LANDSCAPE ARCHITECTURE DESIGN REPORT - ADDENDUM 02

New Primary School in Mulgoa Rise

APPLICATION NO. SSD-11070211

LANDSCAPE SECTIONS

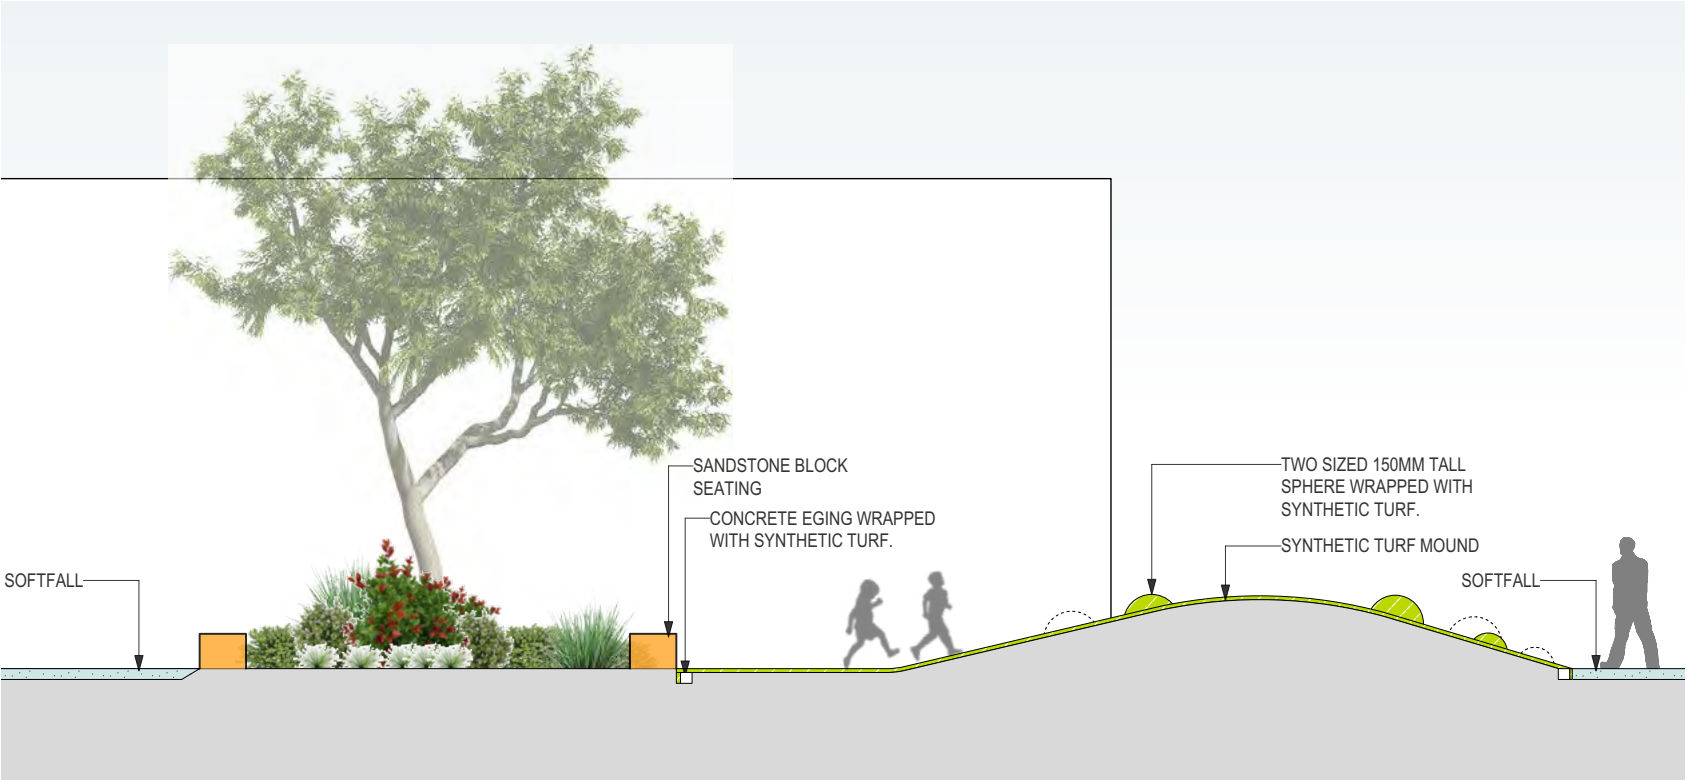
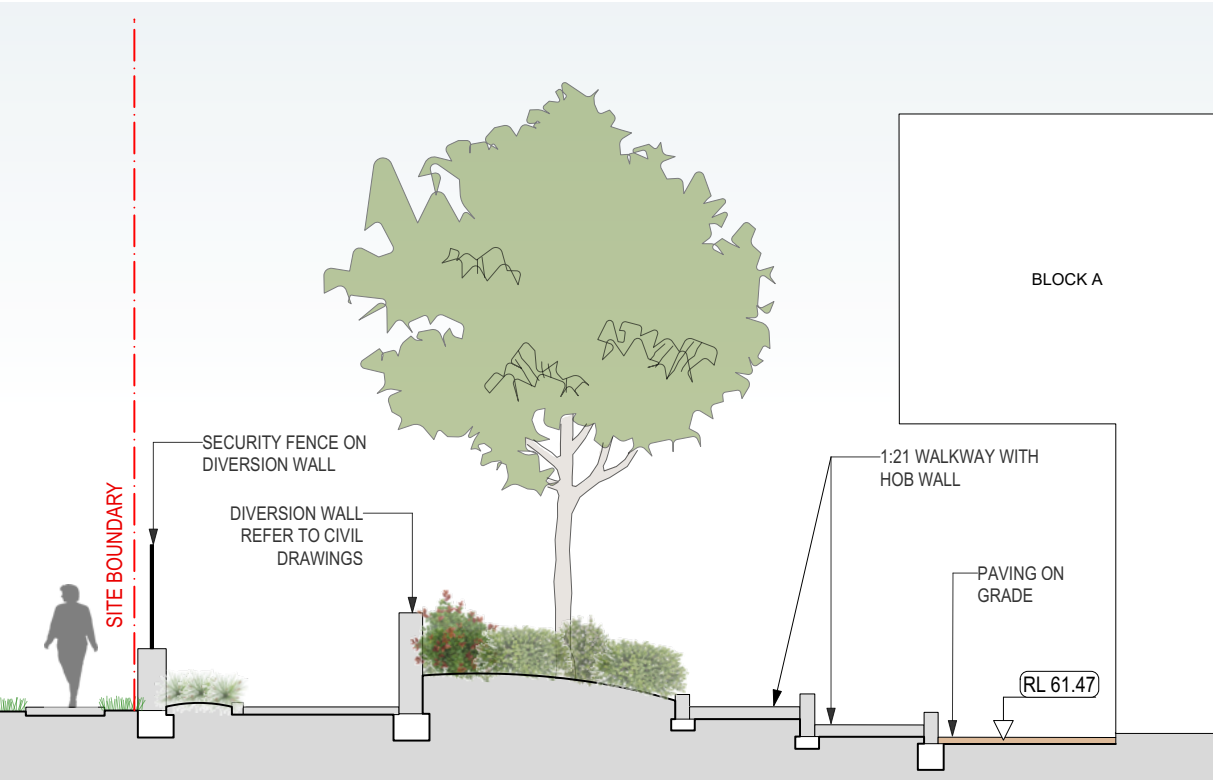
4. Landscape Design Considerations	<p>P.8.4.(a) (a) Landscape plans and cross sections represent proposed level changes and thus must take into consideration proposed engineering and infrastructure and this is to be demonstrated in detailed sections and details.</p>	Currently 3 sections & 1 sectional elevation with design levels and engineering elements included; NBRS to propose 2 additional sectional elevations of both entries for clarity
		<p>P.9.4.(b) (b) Streetscapes Fencing details are lacking - for streetscape amenity fences should be setback from the boundary with landscaping to reduce the visual impact of the fence. Street trees are proposed to be removed to enable accessible parking bays. These street trees should be replaced at a 2 for 1 ratio. Council supports street trees of a suitable size above and below ground in between kerb ramps at accessible parking bays. Additional street trees should be considered in the verge north of playing courts. To further support amenity in the streetscape and wayfinding, the site corner has capacity for large feature trees in association with walls and signage Consistent with Council's Cooling the City Strategy, a continuous and effective street tree canopy is preferred. Street trees should be planted in accordance with Council's Street and Park Tree Management Plan and Appendix. Protection of existing street trees to be retained should be in accordance with Australian Standards and documented.</p>	<p>Fence location is proposed to avoid stormwater infrastructure in the area. Understory planting has been included to reduce the visual impact of the 2.1m palisade fence (EFSG requirement).</p> <p>A greater than 2:1 Ratio is currently achieved along Deerubbin drive (and the remaining site). However, we have adjusted the tree planting in this area to be a staggered line of trees which provide an additional 7 trees.</p> <p>There is an opportunity for additional tree planting to the north of the playing courts, but this area is not within this projects scope of works and any works in this area would be completed by others.</p> <p>A feature tree (<i>Araucaria cunninghamii</i>) will be relocated next to the signage wall to act as a wayfinding element as requested.</p>
